Berry, Huff, McDonald, Milligan Inc.
Engineers, Surveyors

November 12, 2012

RE: Level I-Minor Residential Development Review Site Plan Revisions
Level II-Preliminary & Final Site Plan Development Revisions
Chabad Lubavitch of Maine LLC.
Pomeroy Street

**CROSSWALK DETAILS**

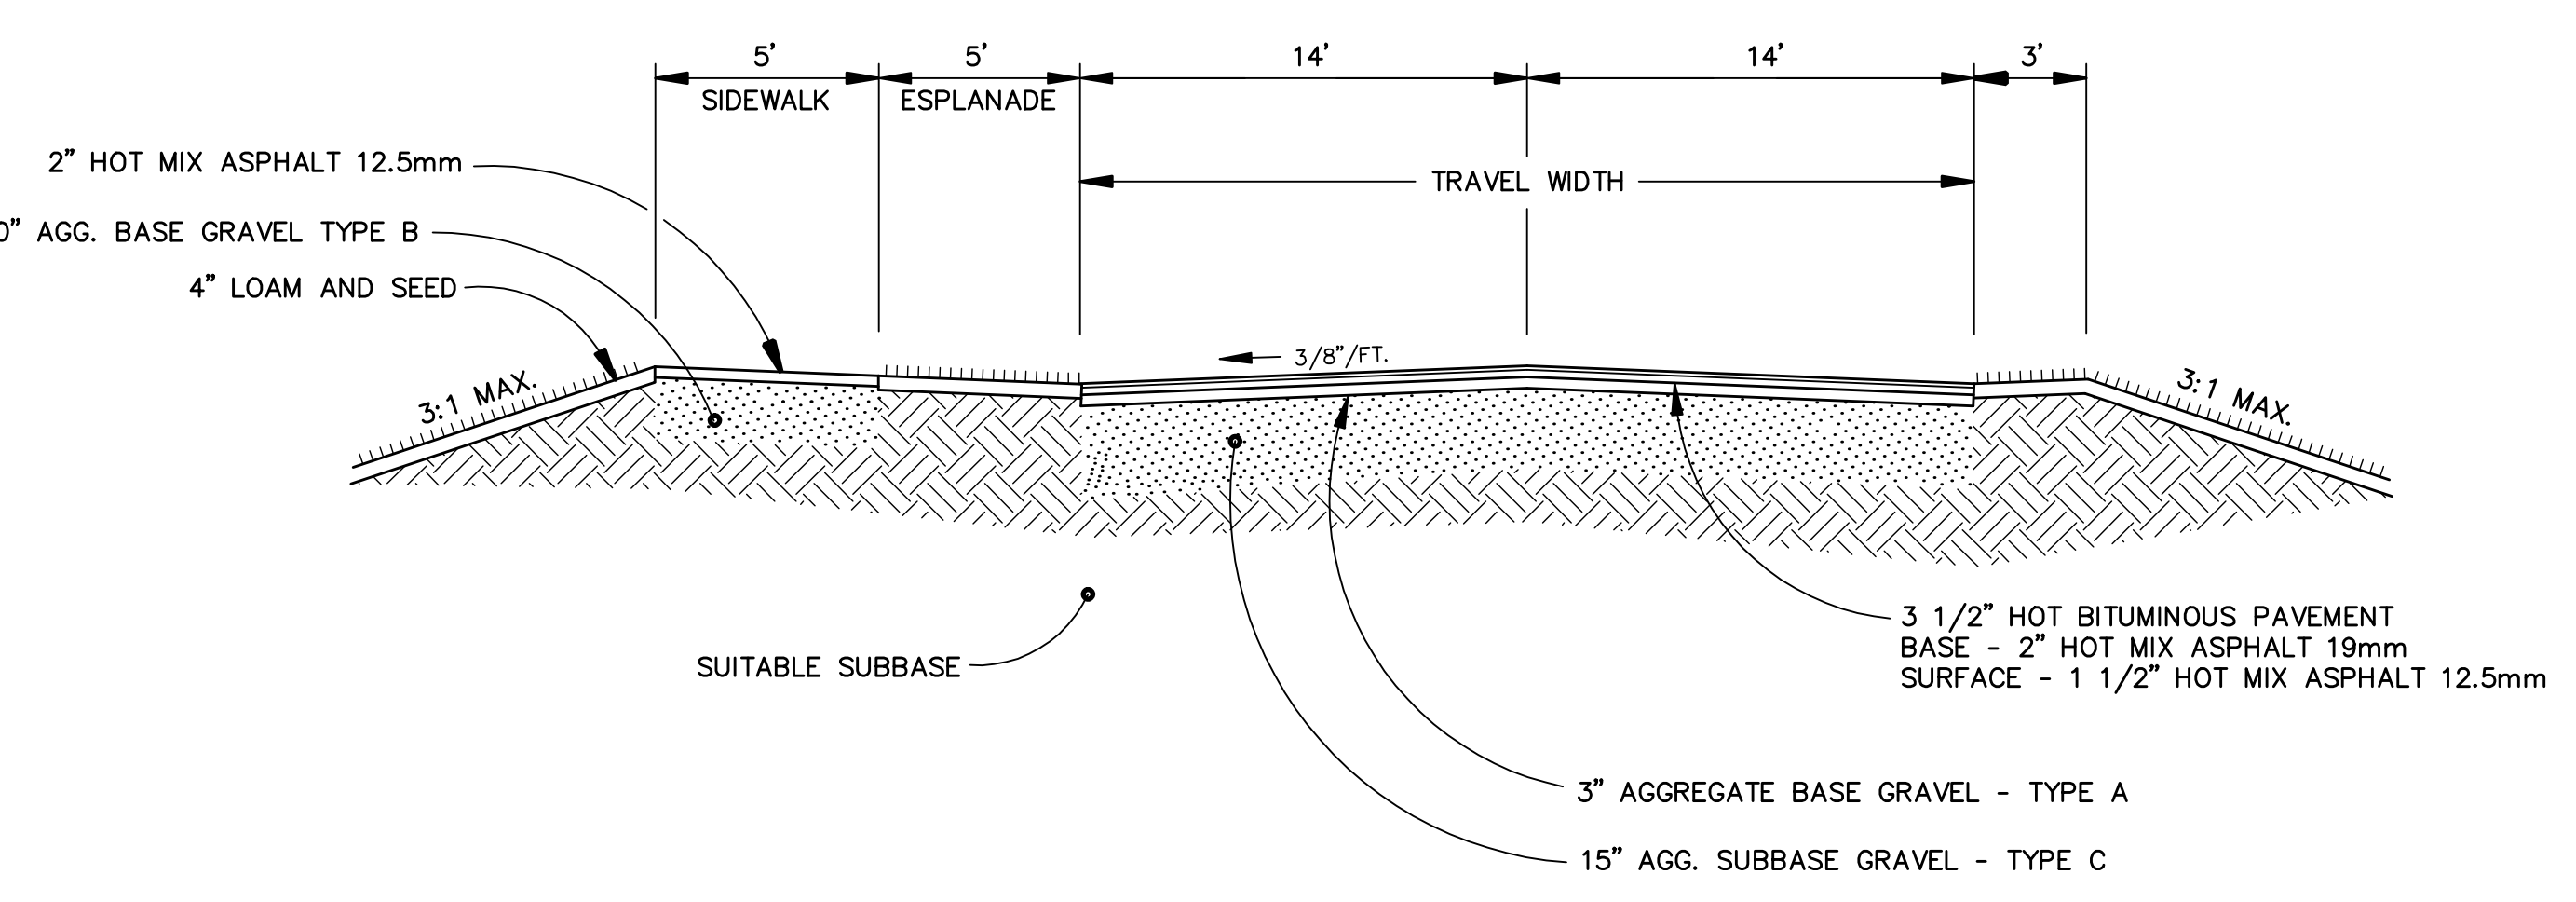
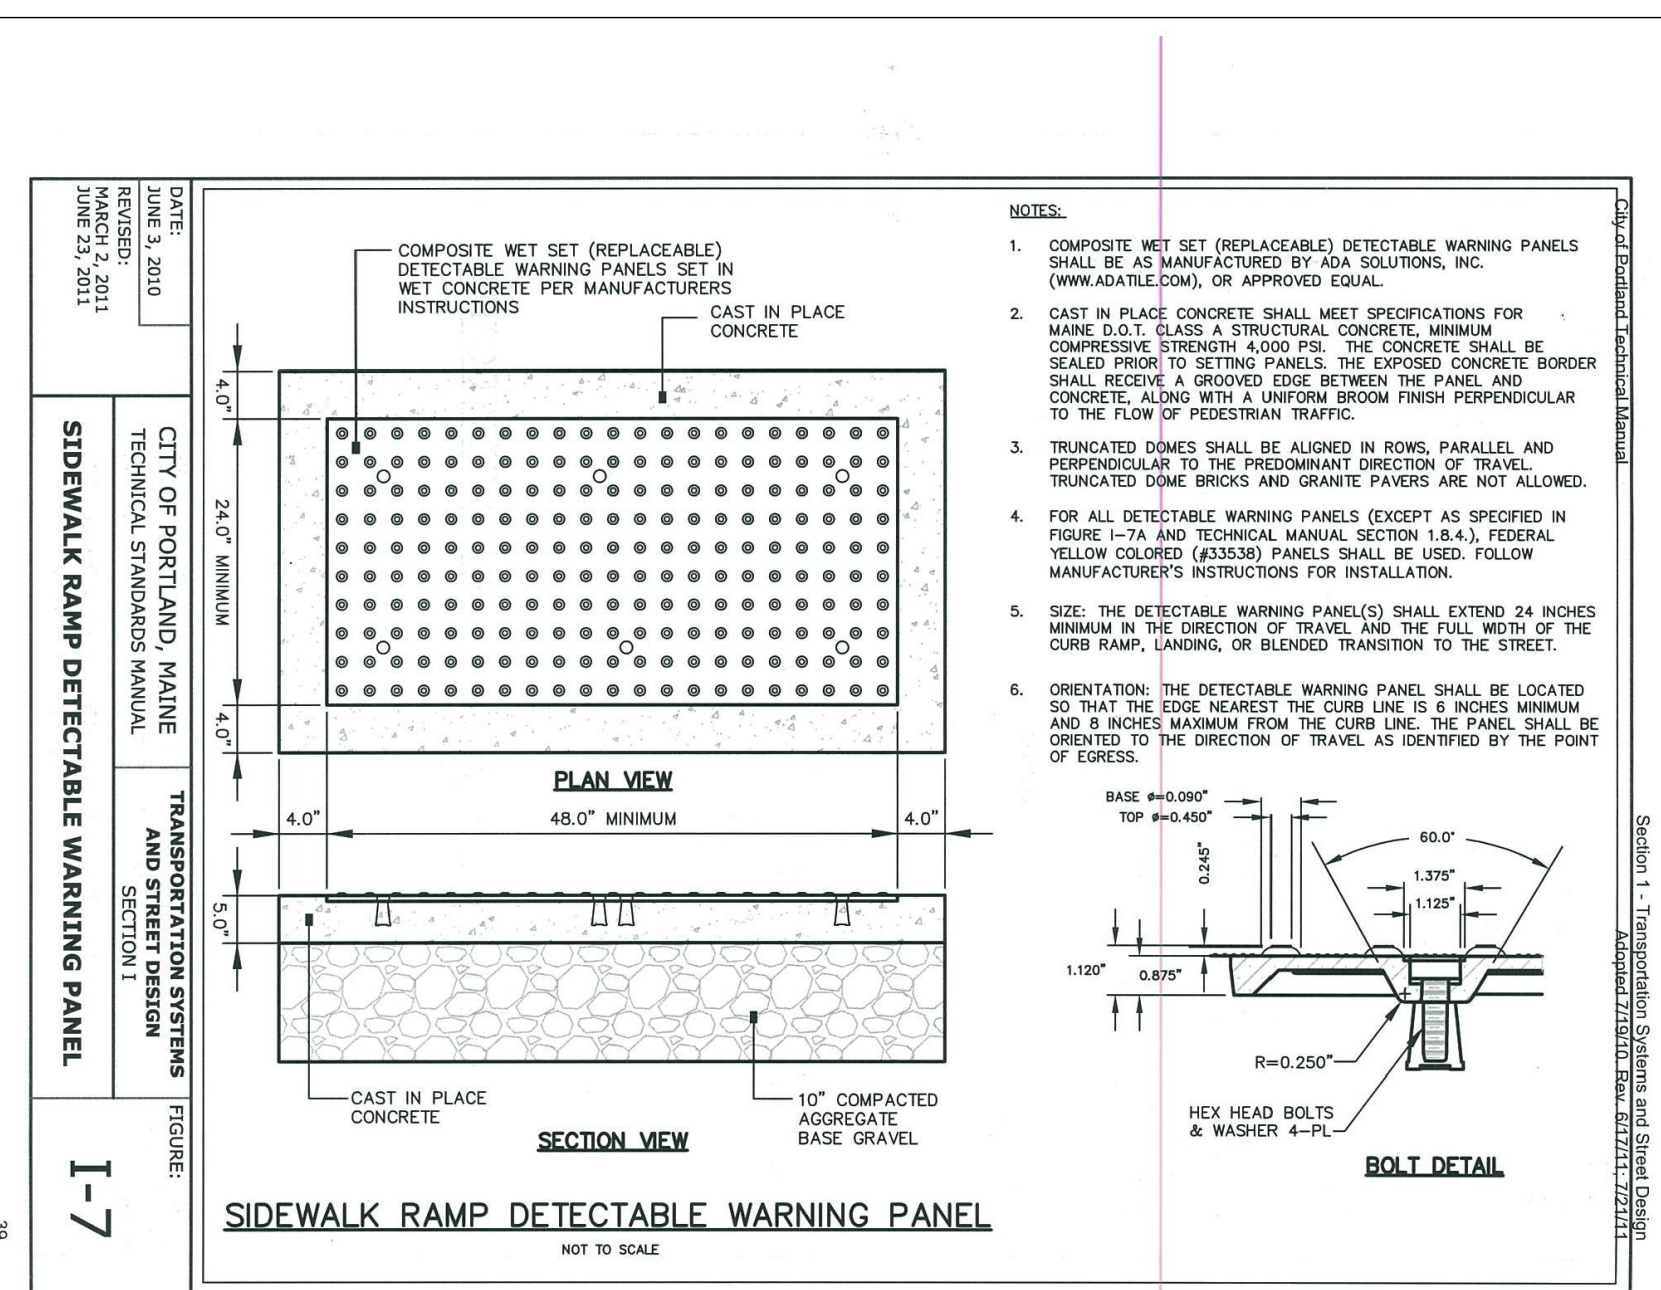
1. The plans have been revised to include a turnaround as required with associated easement (see Sheet 1).
2. The City crosswalk details and ADA Warning Strip Detail has also been added to the details (see Sheet 3).

**ROADWAY SECTION**

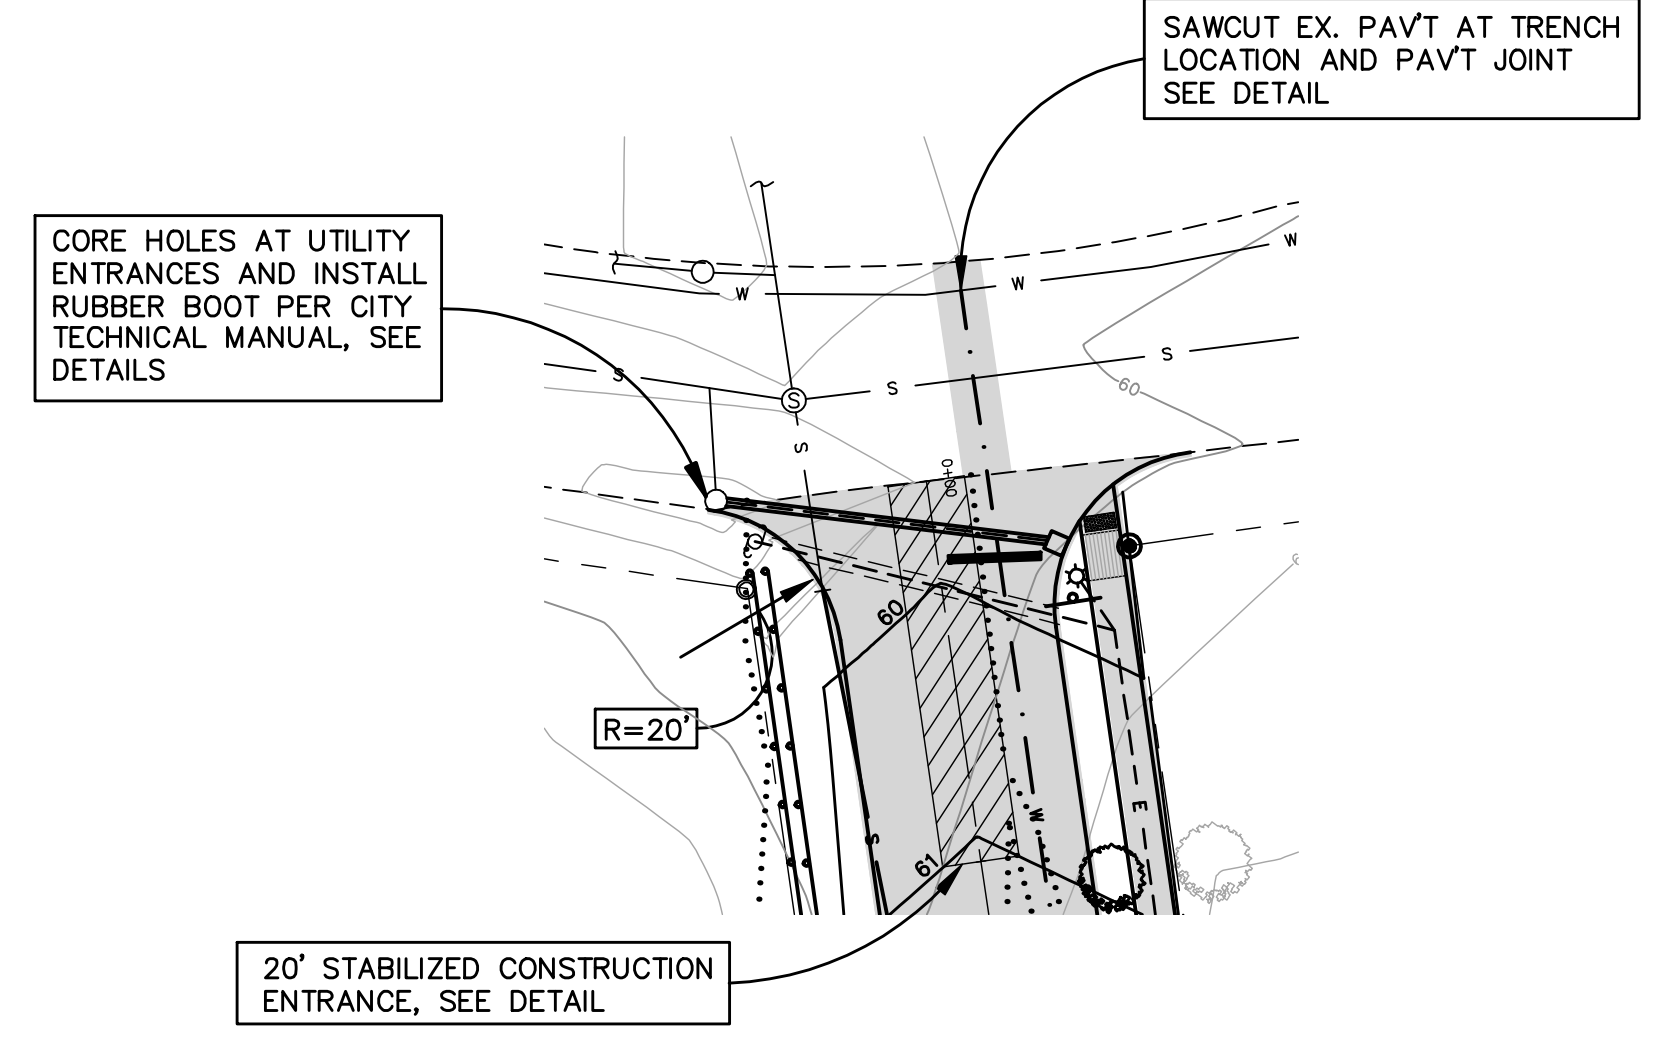
- A. The proposed drainage system and subsequent curbing within Pomeroy Street has been eliminated except for the catch basin at the intersection of Pomeroy and Bancroft Street.
- B. The elimination of the storm drain system within Pomeroy Street includes the elimination of the drainage inlets that the City was concerned with collecting groundwater and subsequently permanently affecting the hydrology of the area.
- C. A culvert was added below the proposed driveway. The culvert will direct runoff from the upstream wetlands under the driveway and into the wetlands on the other side of the site that flow overland to the existing catch basin within Bancroft Street. This culvert was proposed at grade to assure no groundwater from the surrounding wetlands was directed to Bancroft Street and the subsequent combined sewer/drainage line.

The elimination of the curbing proposed along Pomeroy Street will require a waiver from the Department. This waiver is strongly recommended by Mr. Pineo. A waiver is sought by the applicant for the elimination of curbing along the entire length of Pomeroy Street as shown on the Plans. The following is justification for this waiver citing the specific waiver criteria listed in the City of Portland Land Use Ordinance-Section 14-506:

- E. Runoff: As described above, runoff from Pomeroy Street is not required to be collected within a closed drainage system as needed with curbing. In fact, the use of sheet flow and the elimination of the curbing will be a benefit to the City, as this will encourage infiltration within the wetlands, thus reducing the volume of runoff directed to the City's combined sewer/drainage system within Bancroft Street.
